Planning Act 2008 (as amended) – Section 51

Application by Gate Burton Energy Park Ltd for an Order Granting Development Consent for the Gate Burton Energy Park.

Advice following issue of decision to accept the application for examination

Land Plans

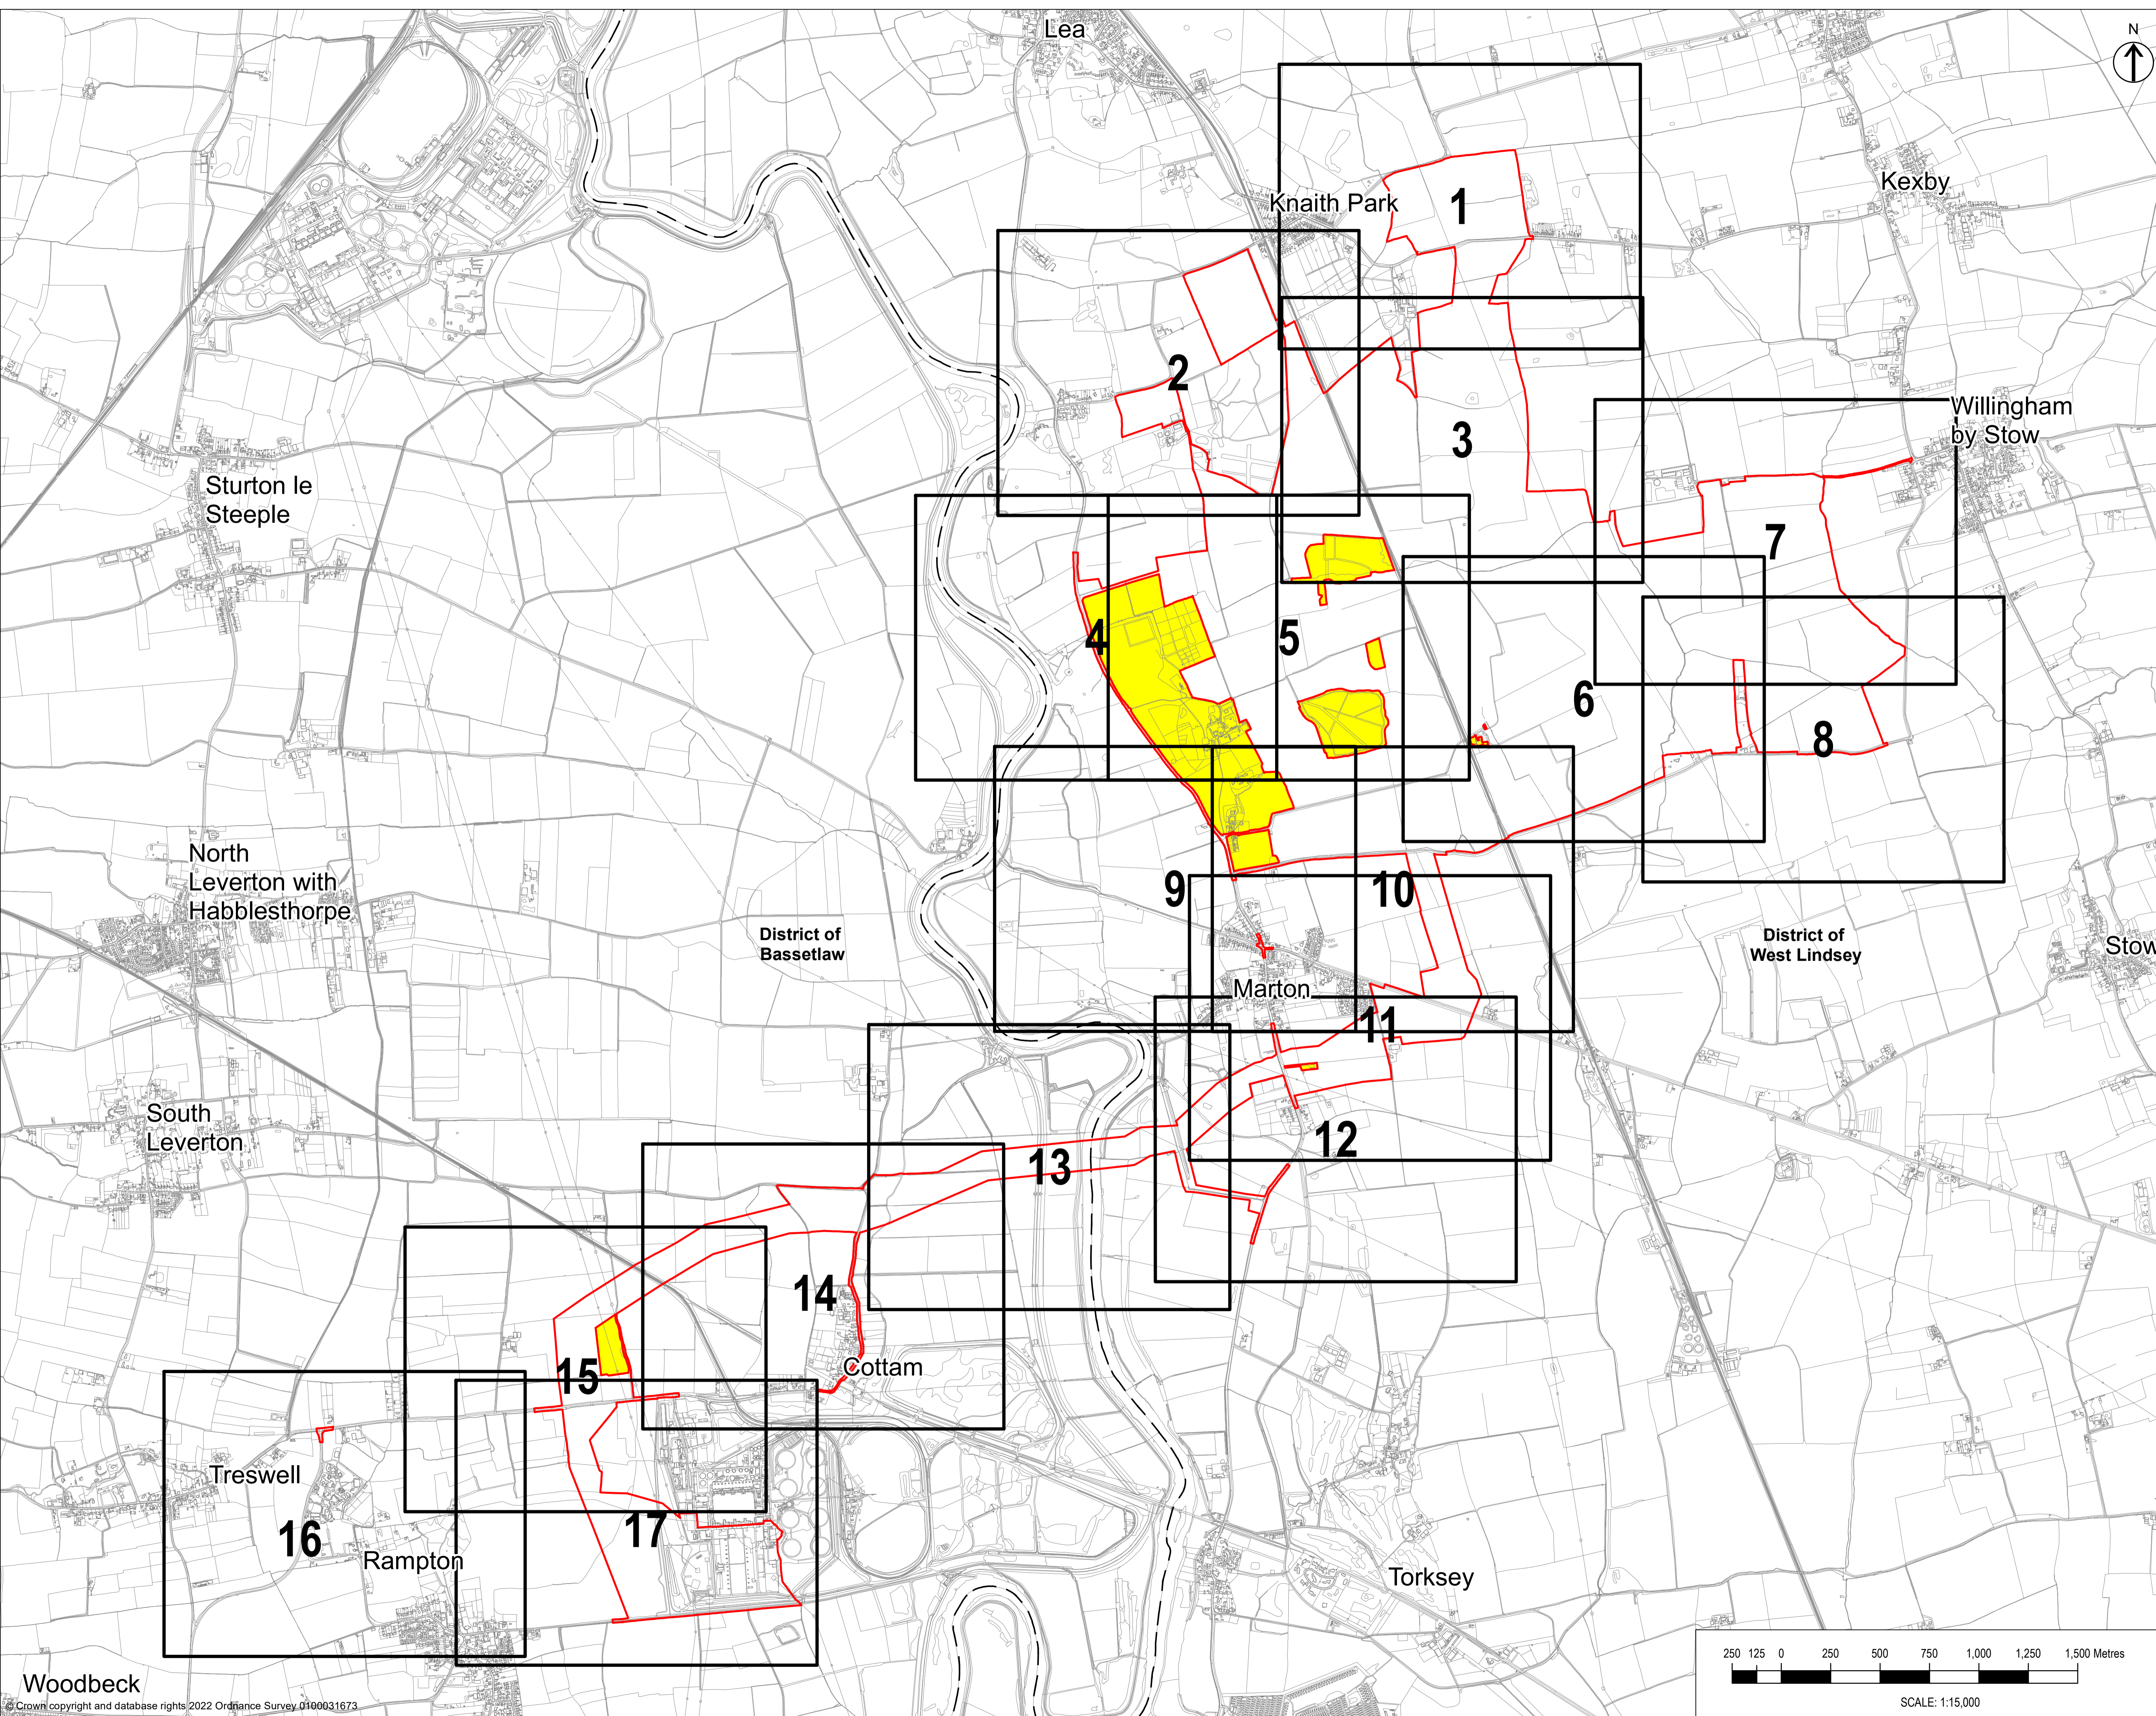
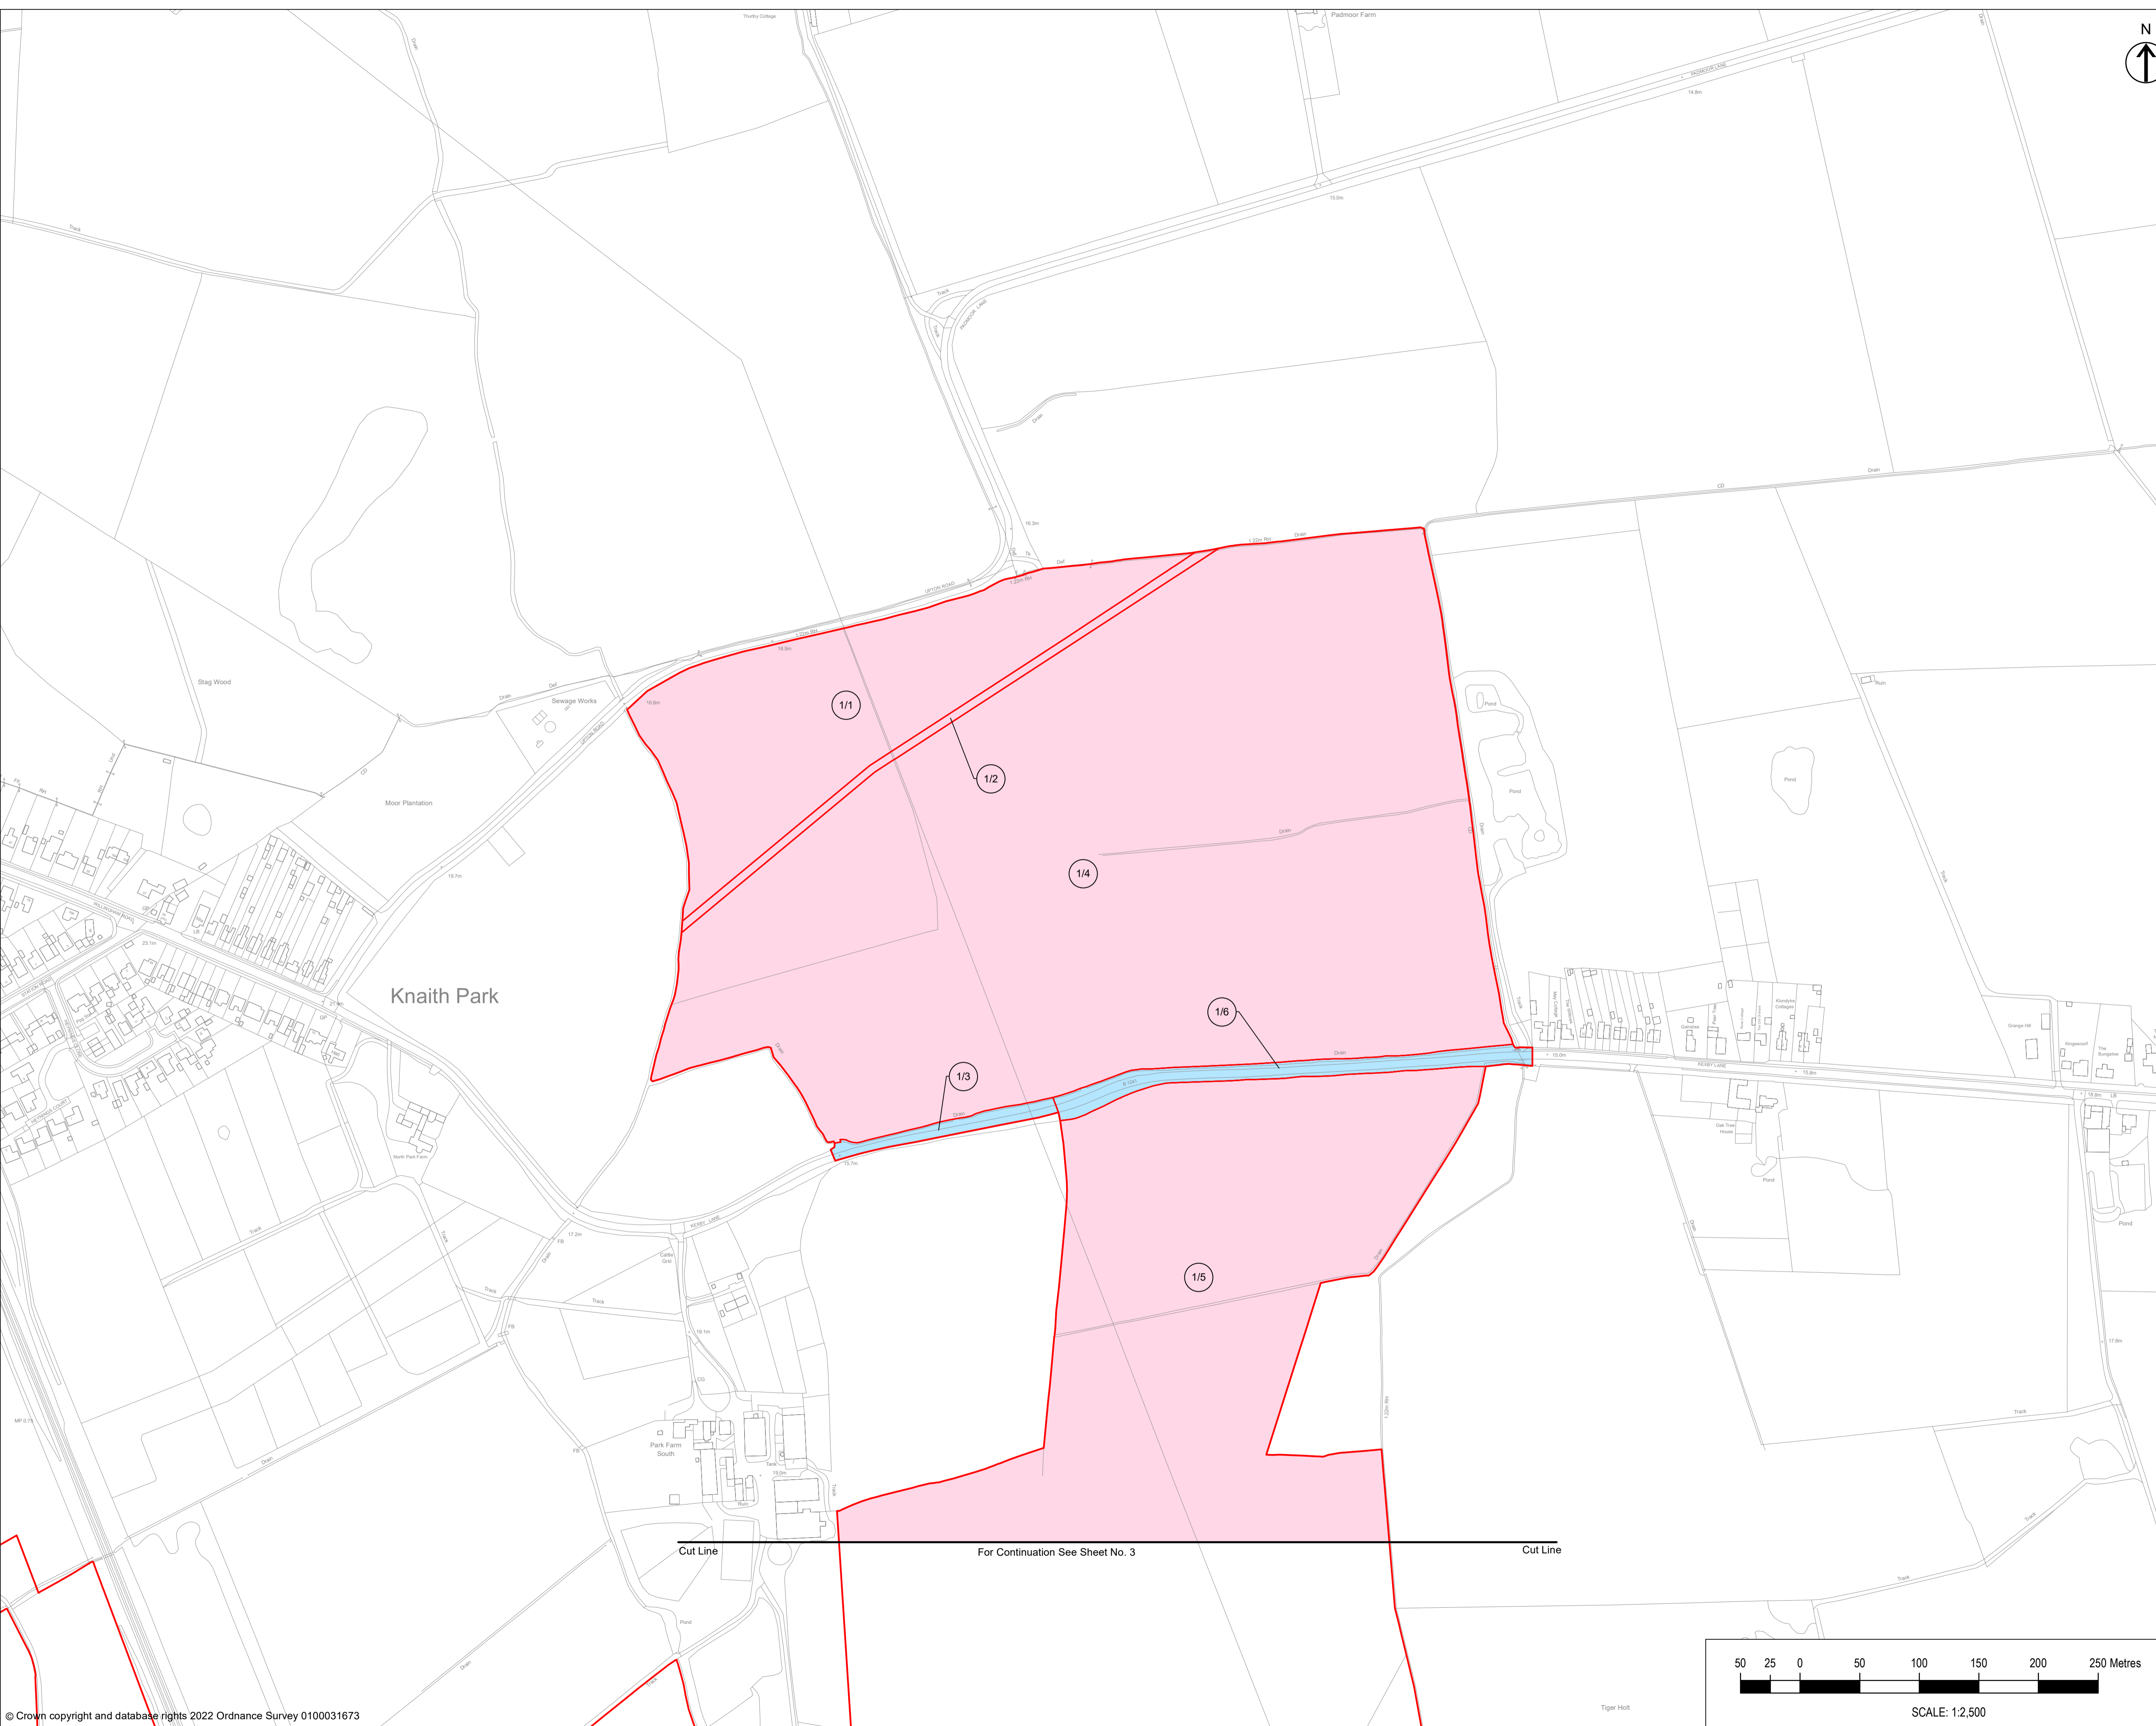
The Applicant is advised to undertake a cross-check of the Land Plans with the descriptions used in the BoR, to ensure clear and consistent read across both documents. Where geographical identifiers, such as road names and settlements, have been used in the BoR to help locate plot(s) on the Land Plan(s), these identifiers should be included on the relevant plan.

A consistency check of the colouring of the plots should be conducted, as well as labelling of inserts on plans, the Applicant should review all Legends on the Land Plans to ensure no typographical errors, as per the errors highlighted in Box 30 of the acceptance checklist.
